LOUISA MAXWELL-WATTERS

WRITTEN REPRESENTATION

HIGHWAYS ENGLAND'S RESPONSE

- 1.1 *We object to the application for the M4 Motorway (Junctions 3 to 12) (Smart Motorway) Development Consent Order Application, concerning alterations to the M4 including conversion of the hard shoulder to a running lane and altering or demolition of existing over-bridges.*

Drawing title
**VEGETATION CLEARANCE
SHEET 19 OF 30
REGULATION 4(2)(e)
DORNEY REACH**

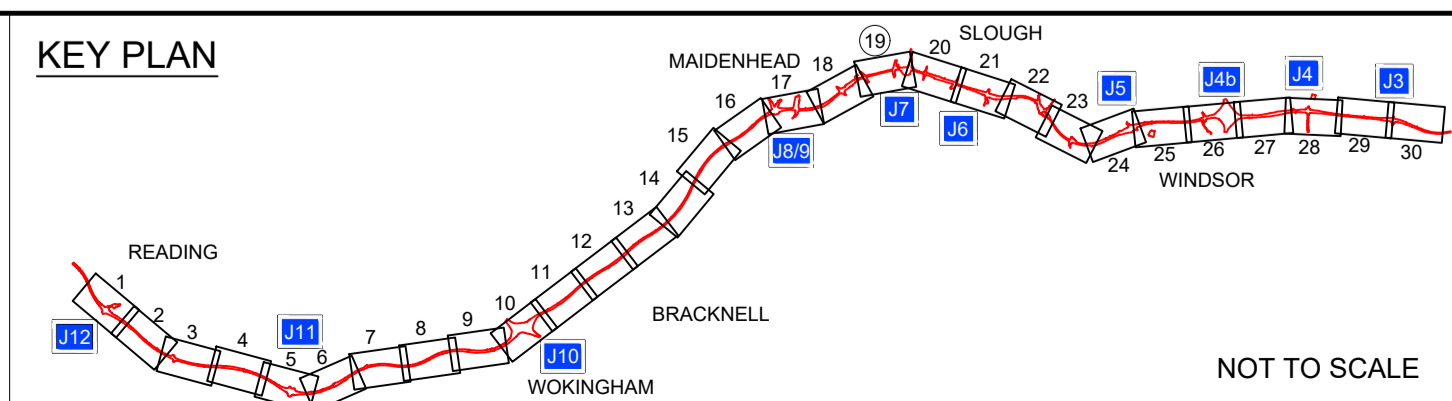
- 1.2 *We are residents and one of the owners of Amerden Lane, a small private road. Land Plan Sheet 19 indicates that Amerden Lane will be used to access a new road for construction traffic which will impact on the residents and surrounding fields and wildlife. We will suffer significant disruption and upheaval as the current plan stands. In addition According to M4 junctions 3 to 12 smart motorway Preliminary Environmental Information report(PEI) (https://projects.ursglobal.com/M4_J3_to_J4_smart_motorway/M4%20PEIR%20-%20Volume%201%20-%20Final.pdf): "Initial access for construction works to the north east side will be via Marsh Lane. However, this access is not suitable for heavy construction plant so the main access will be gained from the motorway by tracking down the embankment". Creating an access down the embankment will remove all the current TPO protected forestation that protects the residents from the noise, atmospheric and light pollution generated by the highway. According to the M4 Junctions 3 to 12: Smart Motorway Environmental Impact Assessment Scoping Report (http://infrastructure.planninginspectorate.gov.uk/wpcontent/ipc/uploads/projects/TR010019/1.%20Pre-Submission/EIA/Scoping/Scoping%20Request/140811_TR010019_%202649169_Revised%20Scoping%20Report%20-%20Version%202%20Final.pdf): "Principle visual effects will arise from the loss of existing screening vegetation, as well as from changes in infrastructure such as side road levels, signing, lighting, and environmental barriers".*

- 1.3 *This forestation took decades to establish and will take decades to re-establish. Expanding the bridge can be done without the proposed destruction for a small incremental engineering cost which will be more than compensated for by the avoidance of the cost of restoring the amenity. While we understand the need to keep the project costs to budget I believe that the current proposal is not a cost reduction but a cost transferal to the borough and the residents.*

- 1.3.4 The vegetation to the existing embankment has to be removed as the embankment at this location is to be widened to allow for the revised horizontal alignment of the motorway, as shown on the cross sections at chainages 31+400 and 31+100; these cross sections are included on sheet 2 of the Engineering Sections drawings (Application Document Reference 2-4).

1.3.10 It should be noted that, contrary to the suggestion of the representation, the vegetation on the existing M4 embankment which is to be removed is not protected by Tree Preservation Order(s) ("TPO"). The impact of removal of vegetation will be mitigated where possible. When used for access, only necessary vegetation removal will be undertaken. Any pre-construction surveys considered necessary to determine this will be actioned via the CEMP, and any mitigation measures considered necessary will be secured in the CEMP and implemented to ensure the ecological resource is safeguarded, for example fencing off vegetation to be retained, programming vegetation removal to avoid the bird nesting season where possible, and undertaking vegetation removal under the supervision of an ecologist. The CEMP is secured under Requirement 8, Schedule 2 of the draft Development Consent Order ("DCO") (Application Document Reference 3-1).

- 1.3.13 On completion of the embankment widening work, a reinstated 20m wide strip of woodland planting will be provided along the toe of the new reinforced embankment as per the Environmental Masterplan (Annex A1 of the Engineering and Design Report (“EDR”) (Application Document Reference 7-4)). It is expected that the proposed tree planting would achieve a height of between 5 and 7m by the Design Year (2037), 15 years after construction. Both landscape and visual effects would reduce to slight adverse by the Design Year (2037 - 15 years after construction) due to establishment of this planting.
